**C. Consultation responses from
English Heritage and Campaign for
Protection of Rural England.**

Request for Pre-application Advice

**PROPOSED HERITAGE/VISITOR CENTRE, MILL ROAD, ARUNDEL, ARUN,
WEST SUSSEX, BN18 9PA**

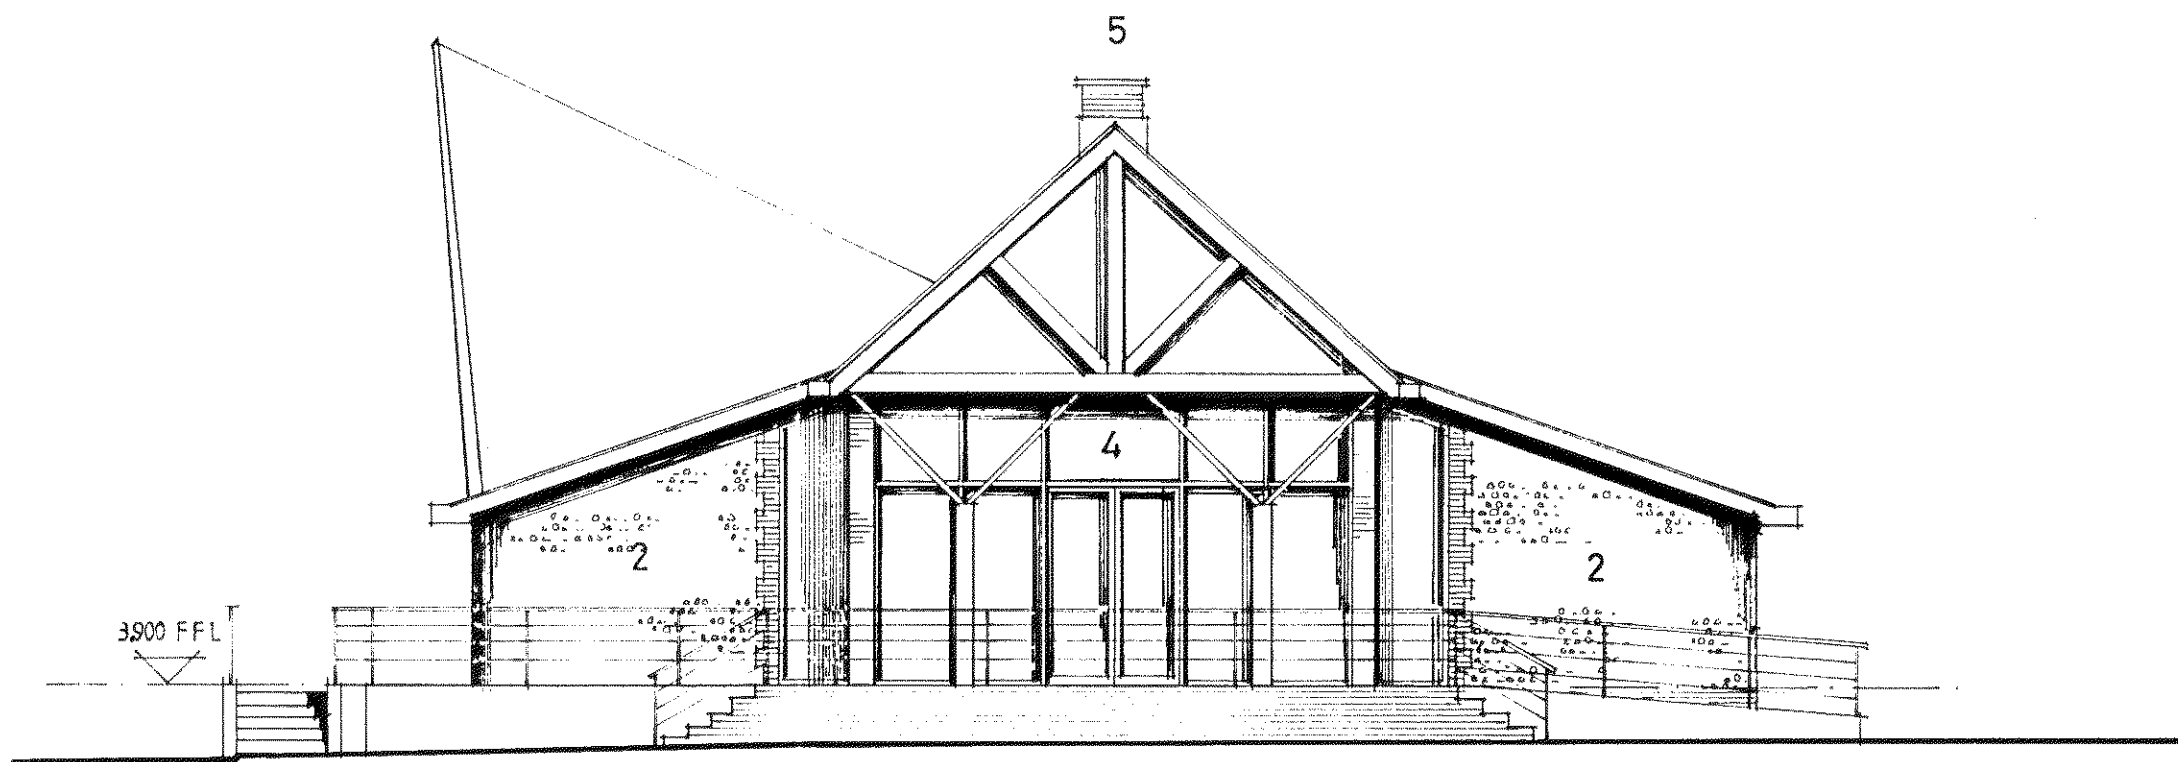
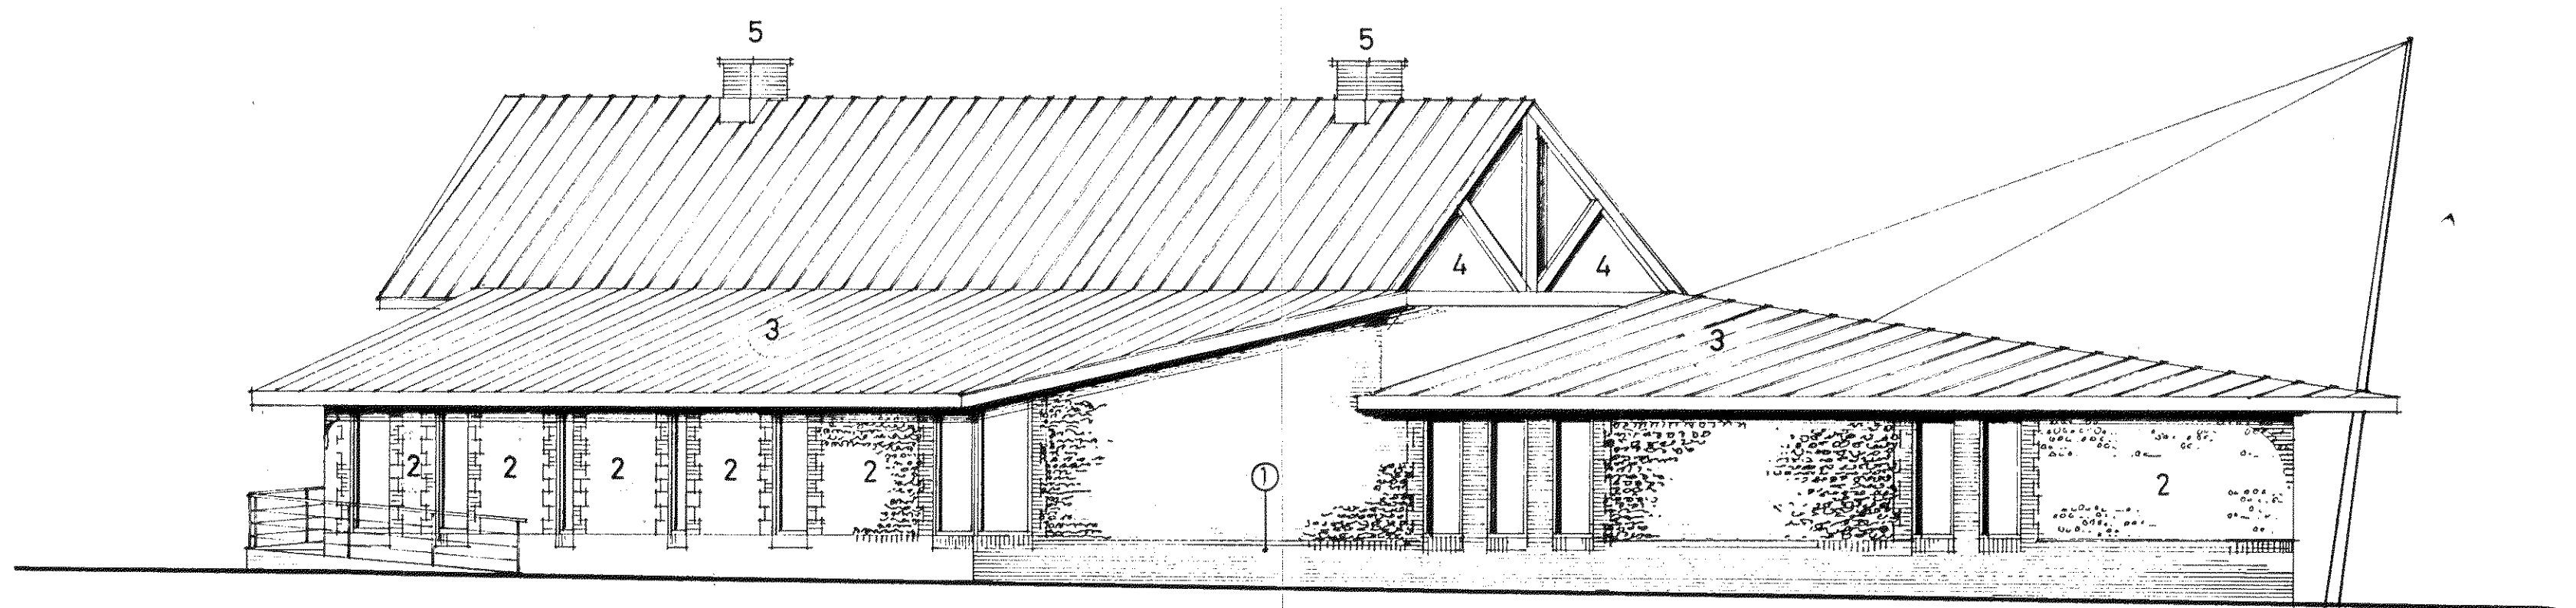
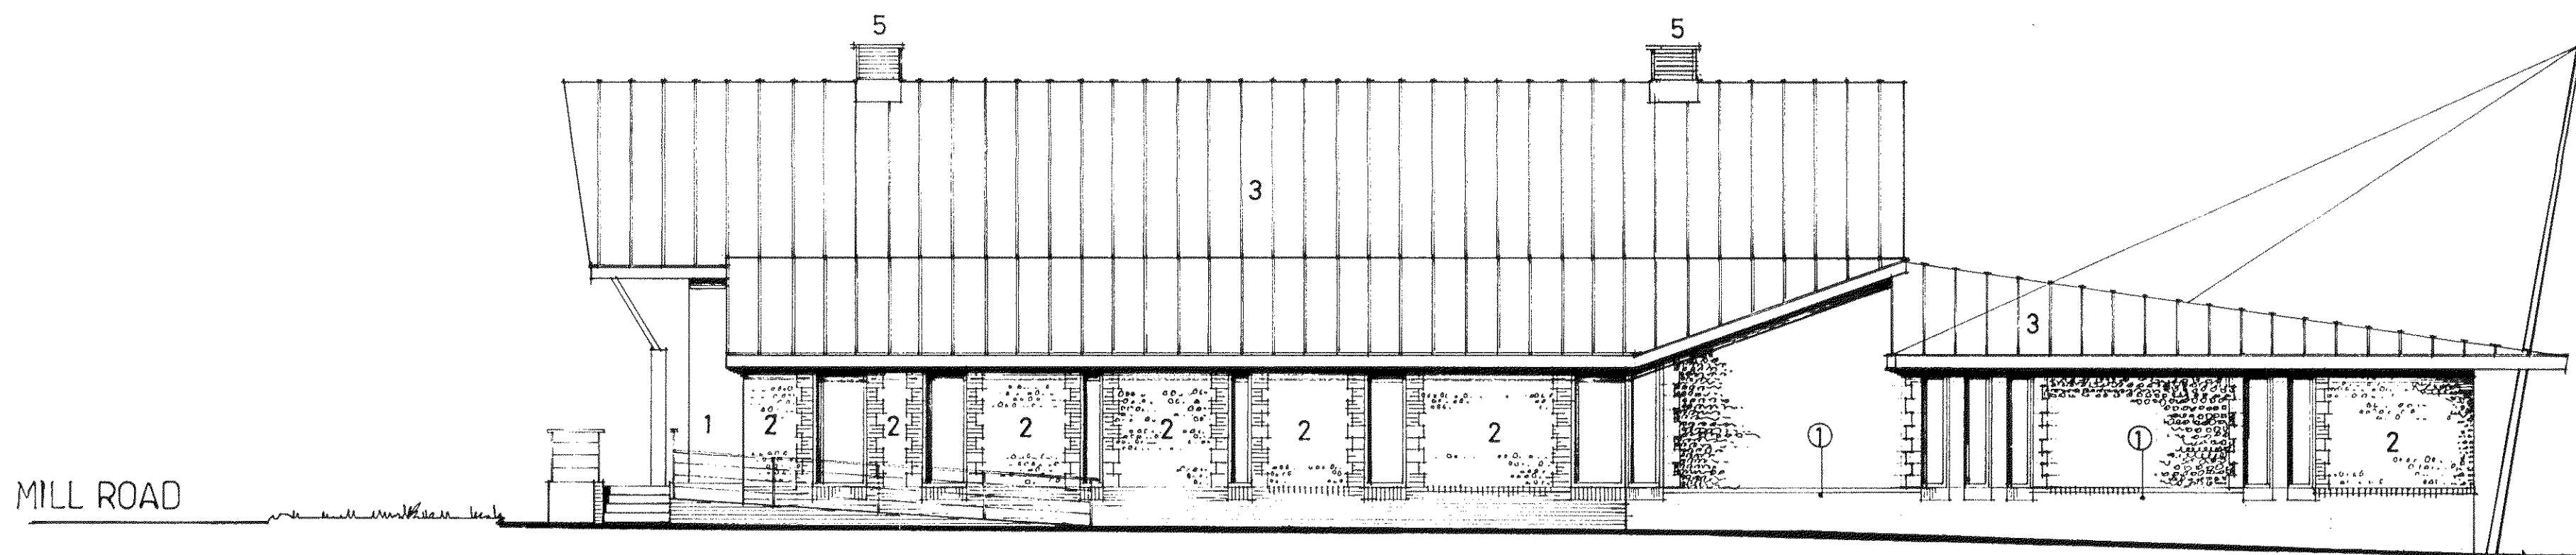
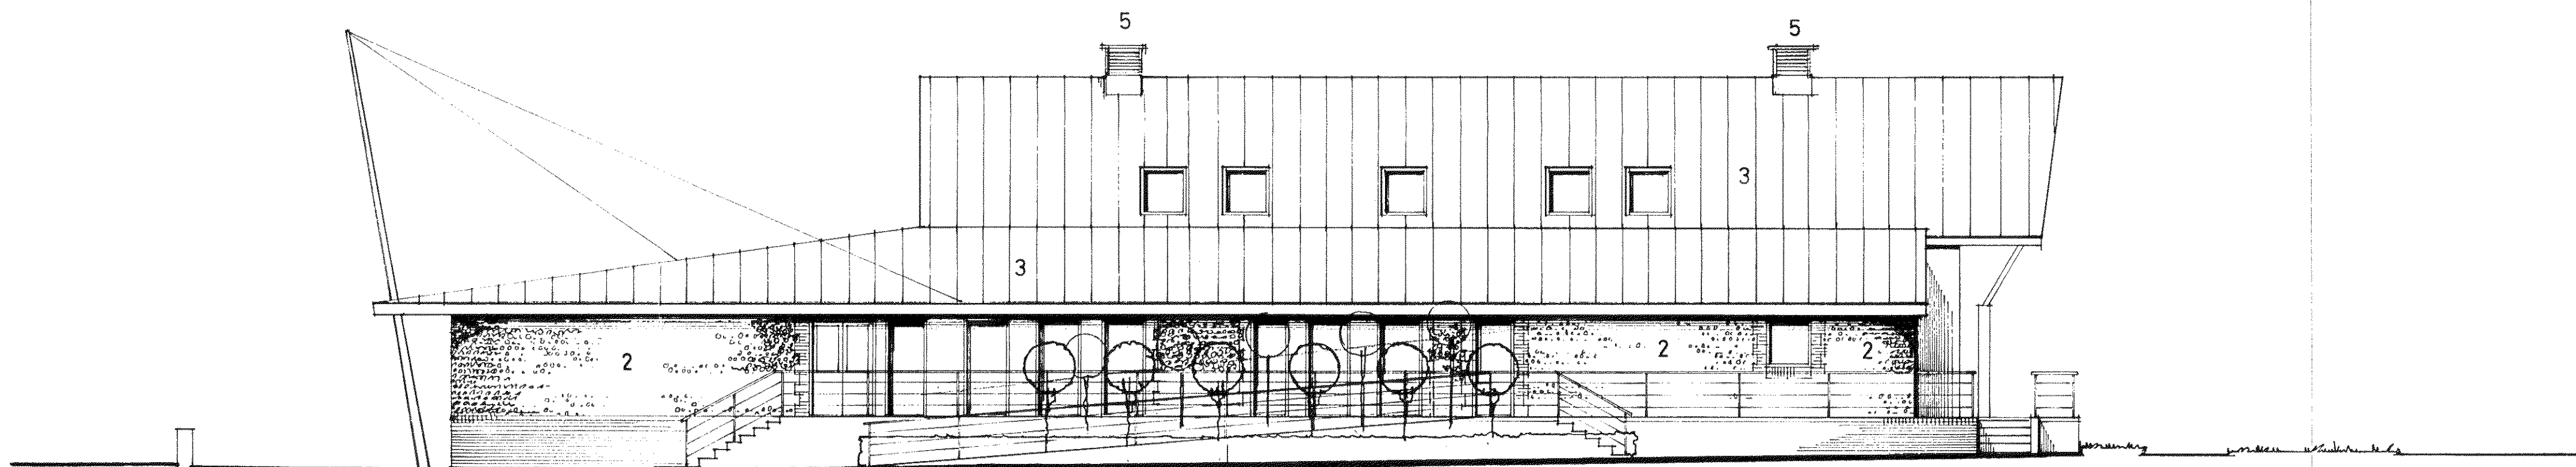
You advised that the construction will be in flint and brick, rather than solely brick as shown on the plan, and that the roof will be in grey metal with ridging to reflect the roof on the main castle buildings. You also confirmed that the round "sentry box" structure in front of the development will not be built.
